# Derrygreenagh Power Submission

**Cllr Liam Quinn**

319023 (SID Application)

Combined Cycle Gas Turbine and Open Cycle Gas Turbine Thermal Power Plant, Electricity Grid Connection including 2 no. substations, and associated buildings, plant, site works, service and ancillary development.

TITLE:
**PROPOSED DEVELOPMENT - OVERVIEW PLAN
(SHEET 1 OF 8)**

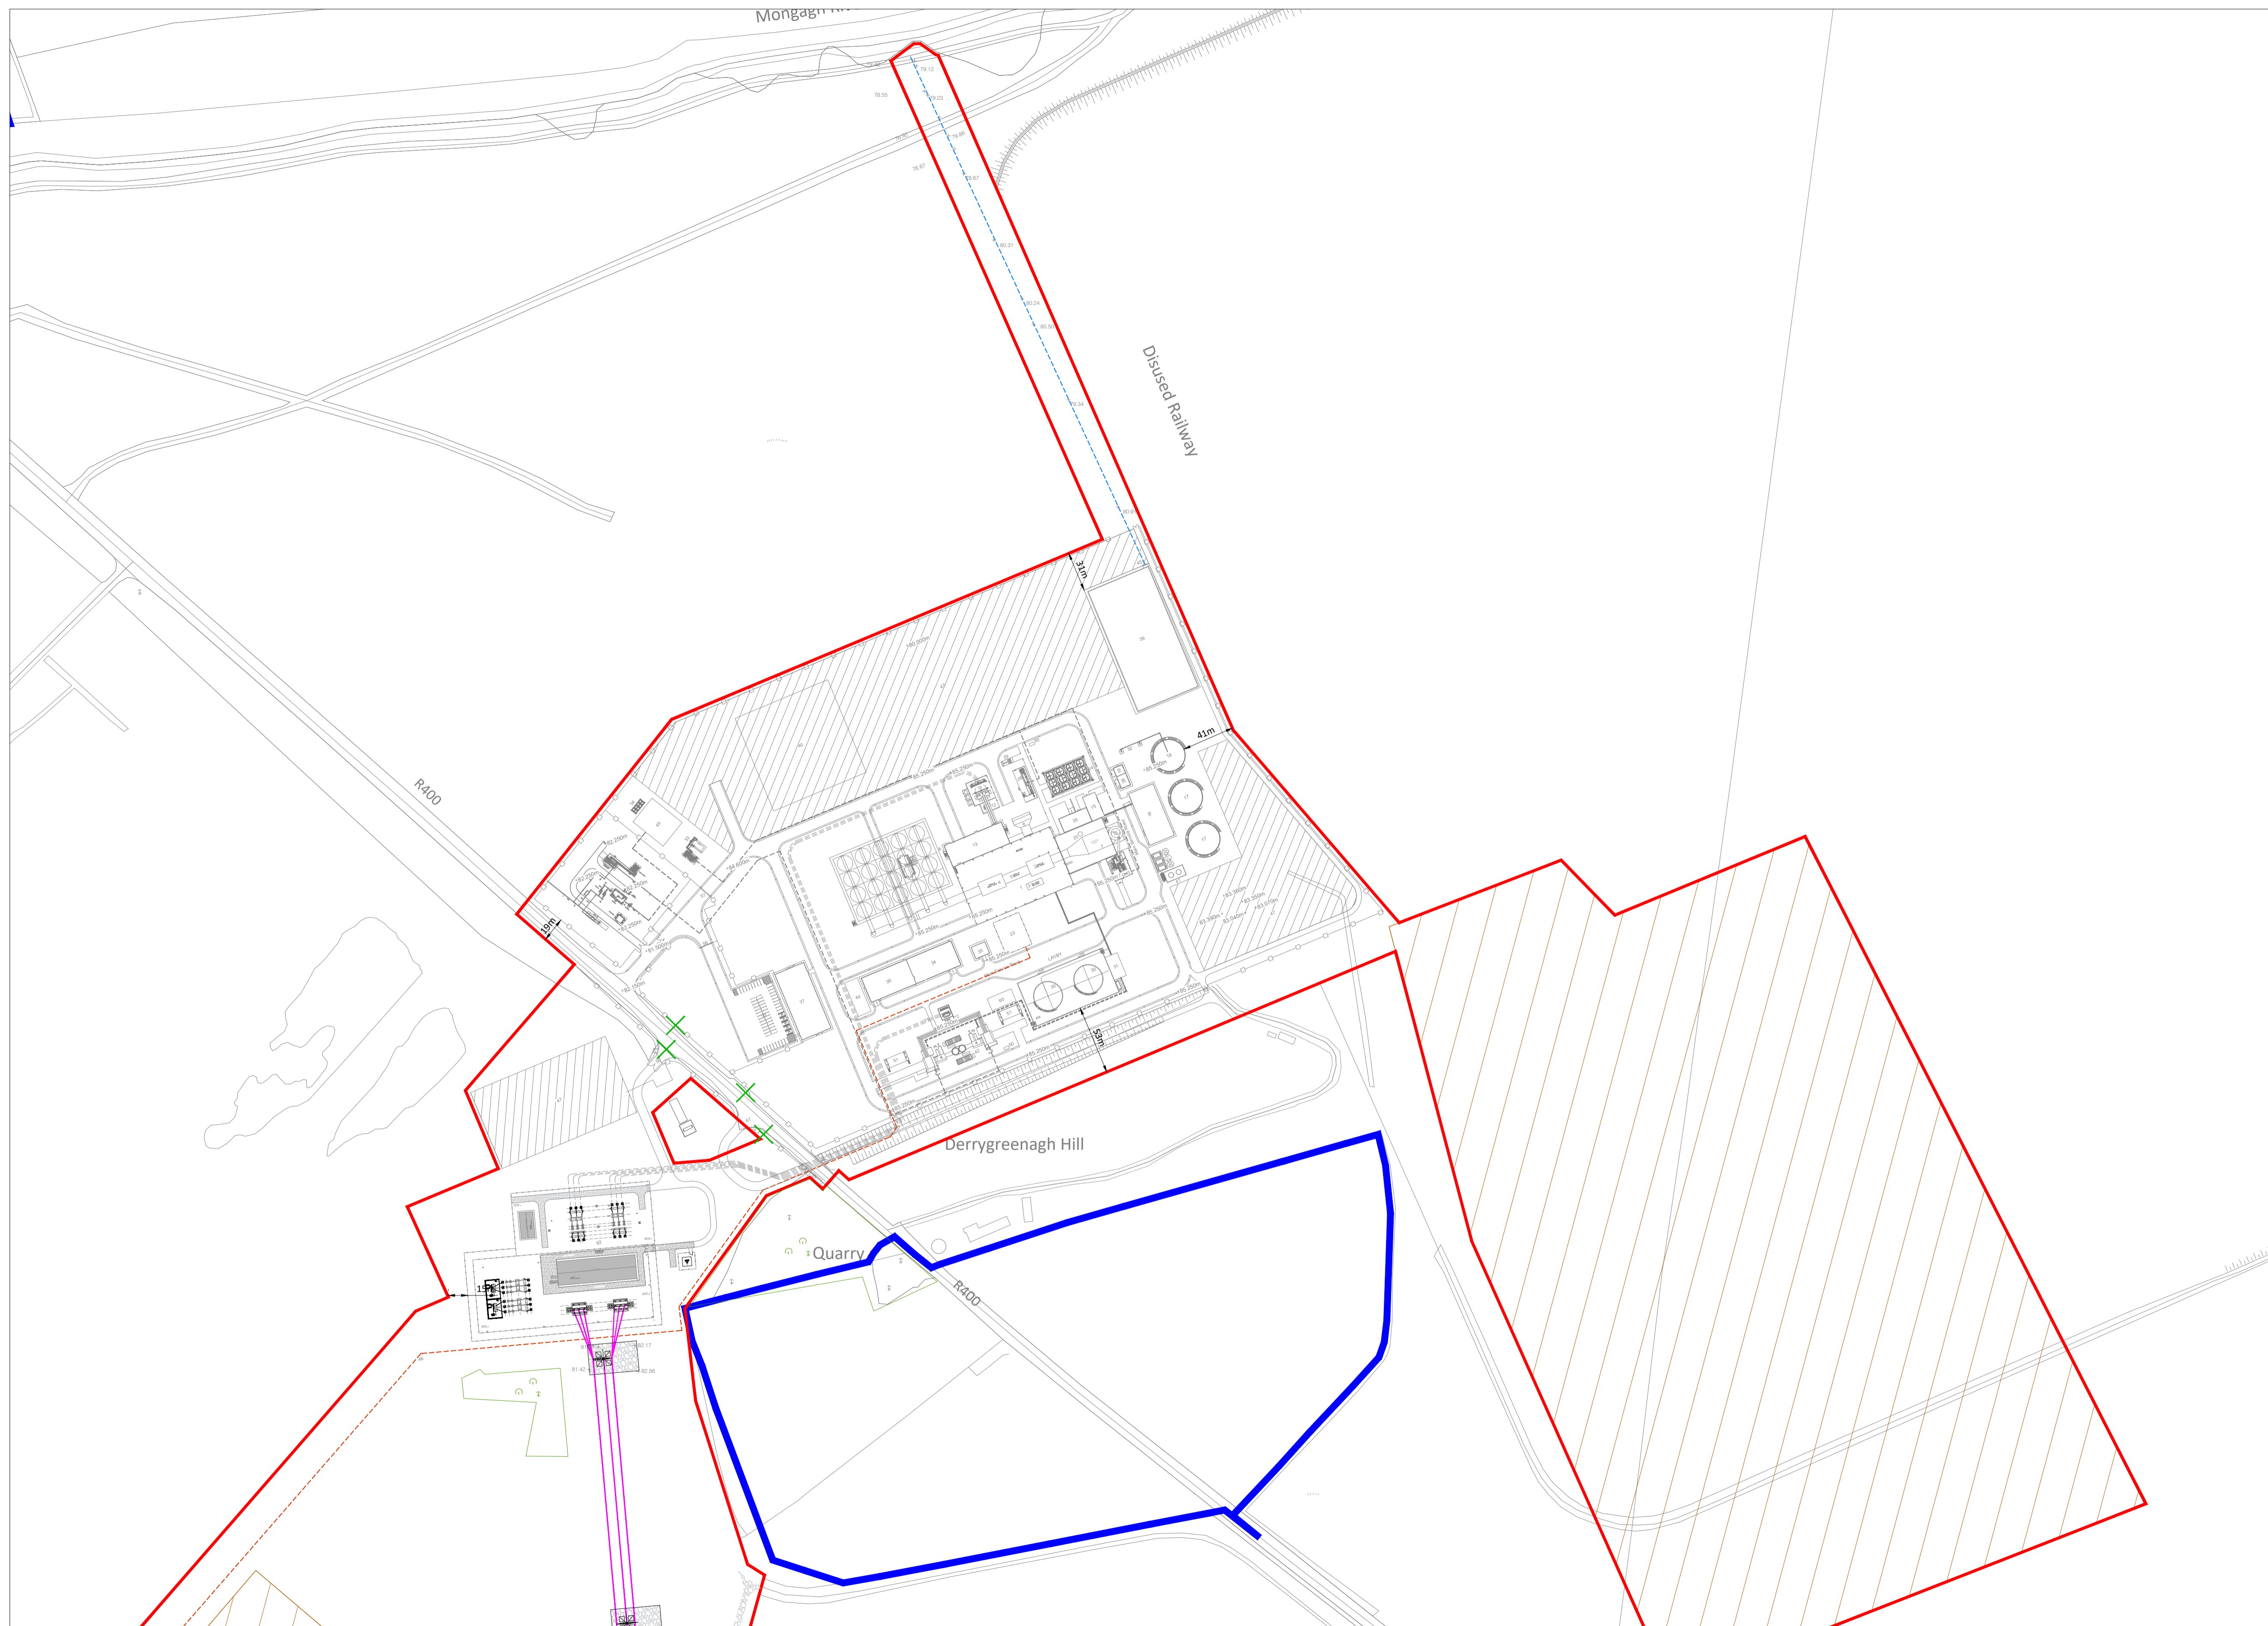
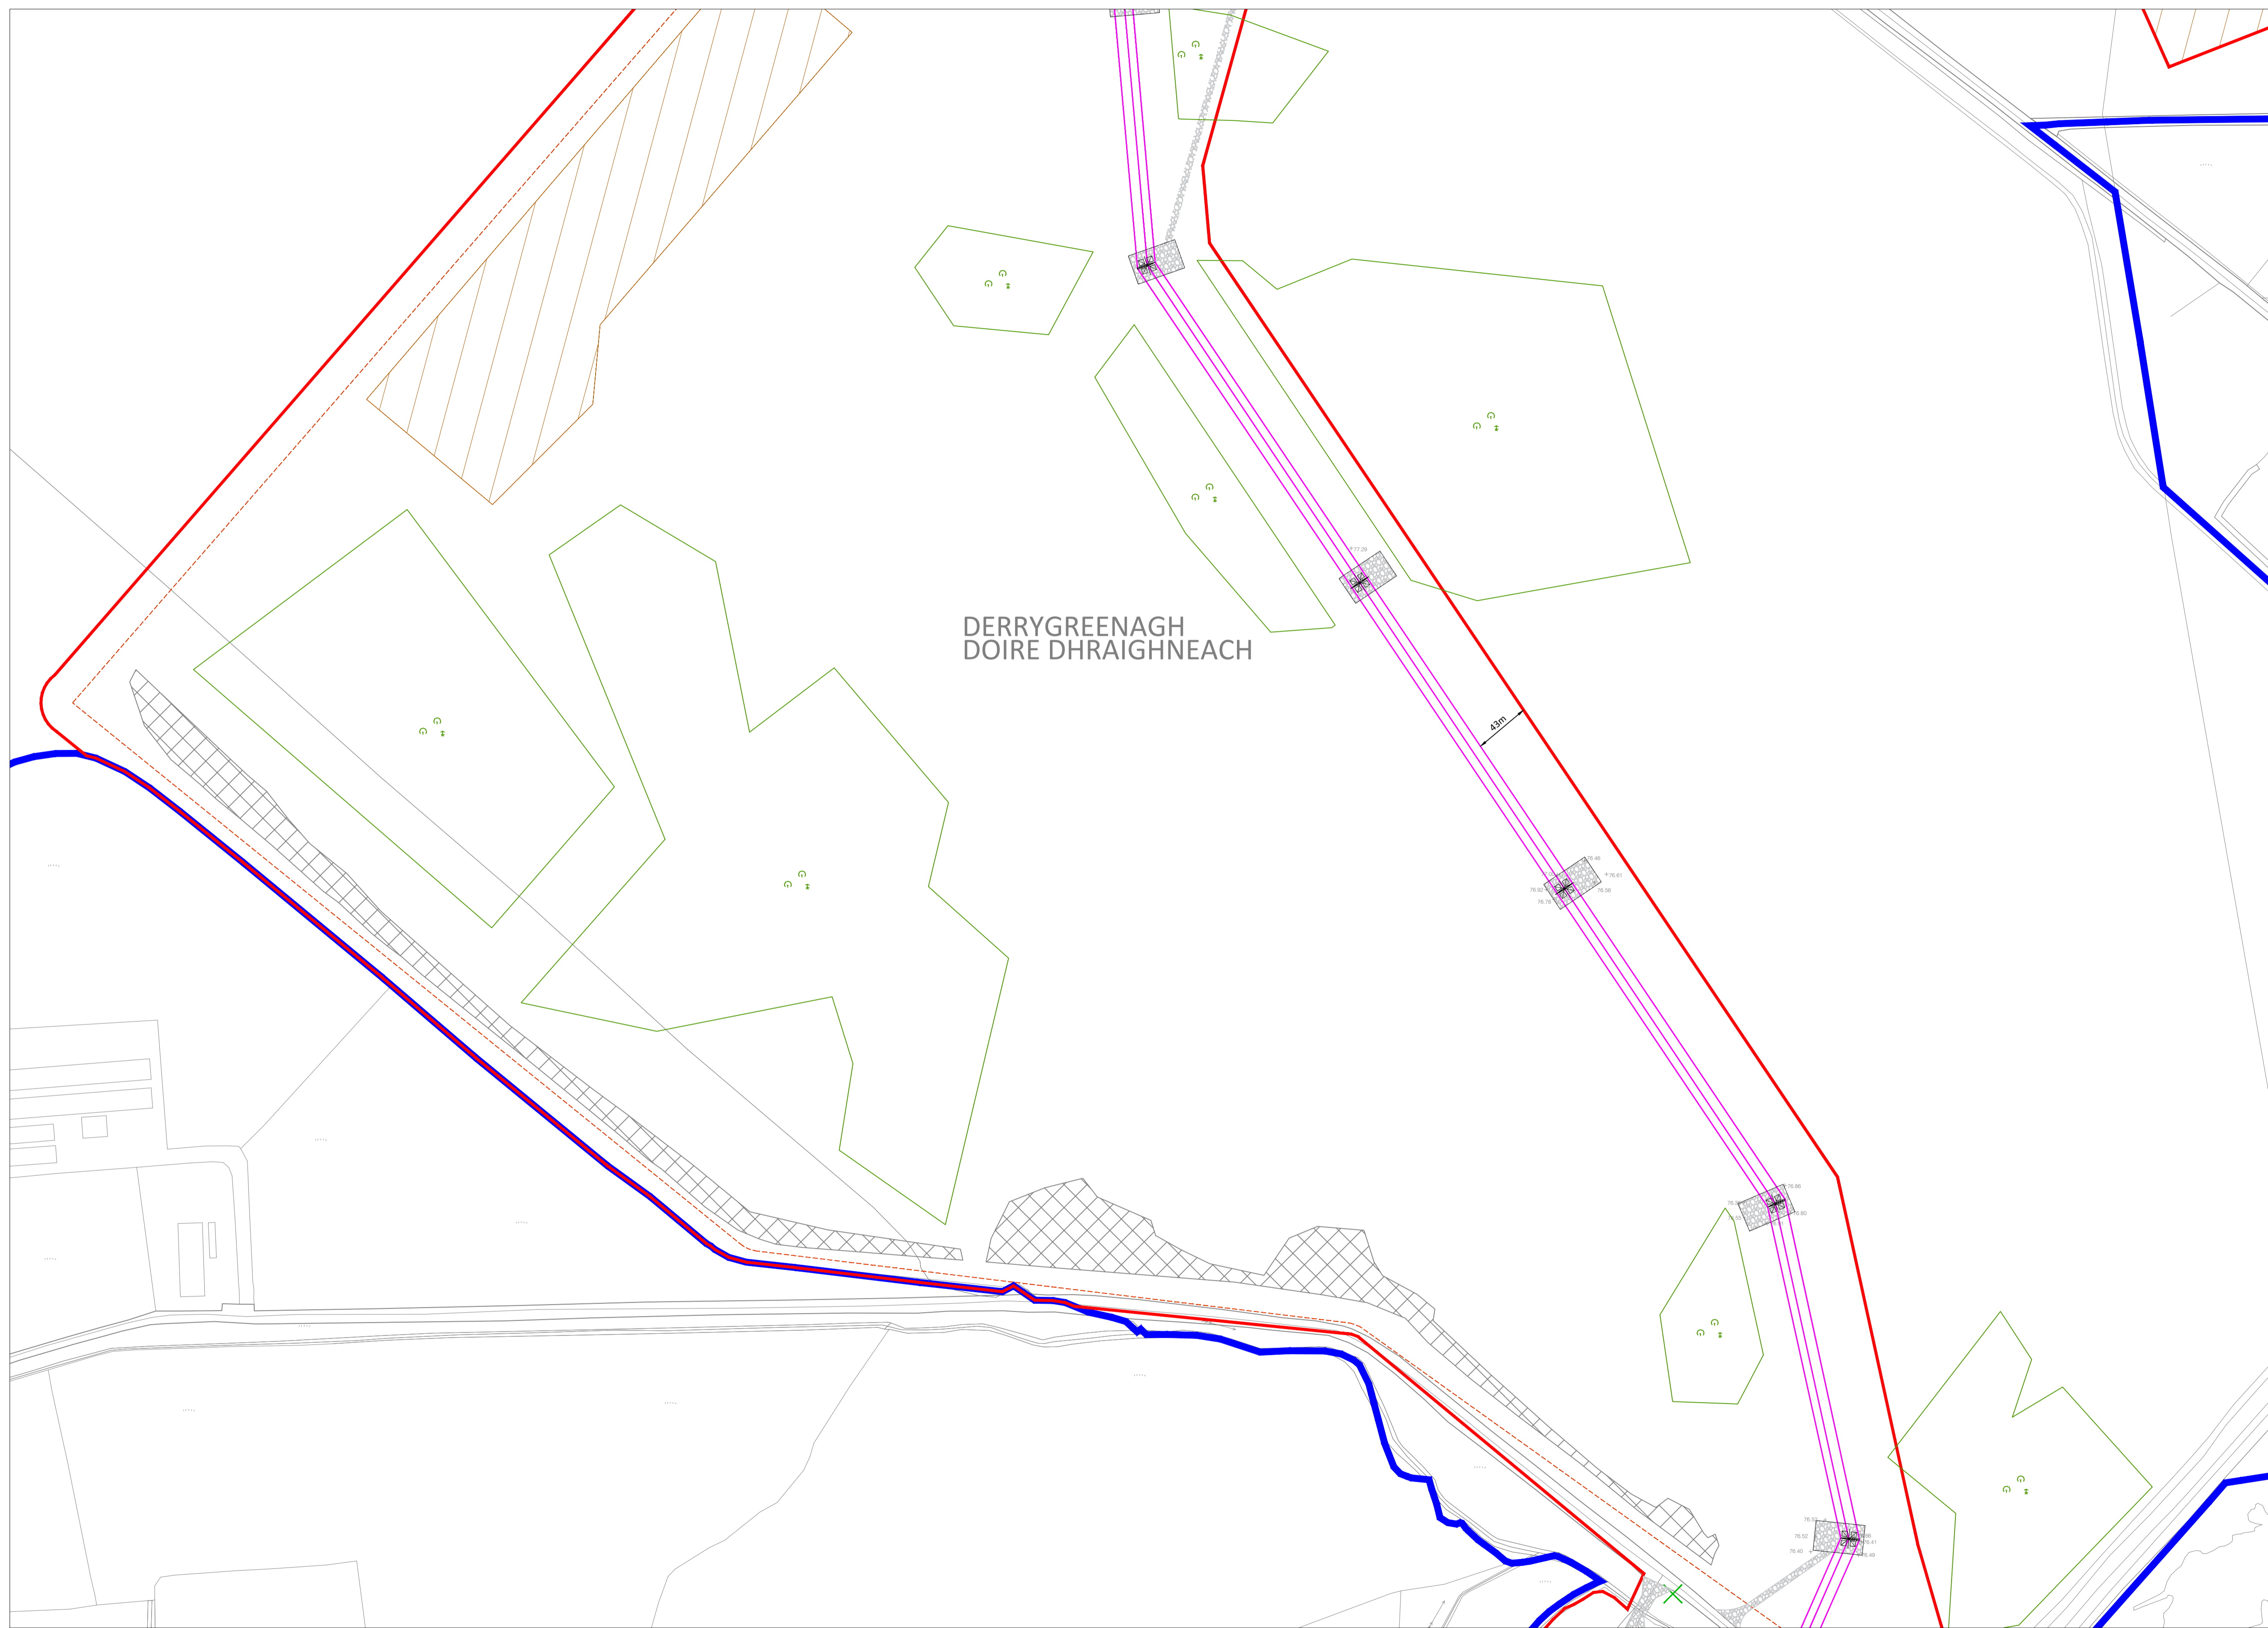
1. The cabling connecting this development to the substation be located entirely underground with no **overhead wires/pylons permitted**.

The proposed cable way will have a major visual impact on the surrounding countryside. This imposition can be overcome by undergrounding the entire cable way from Derrygreenagh to Tubberdaly.
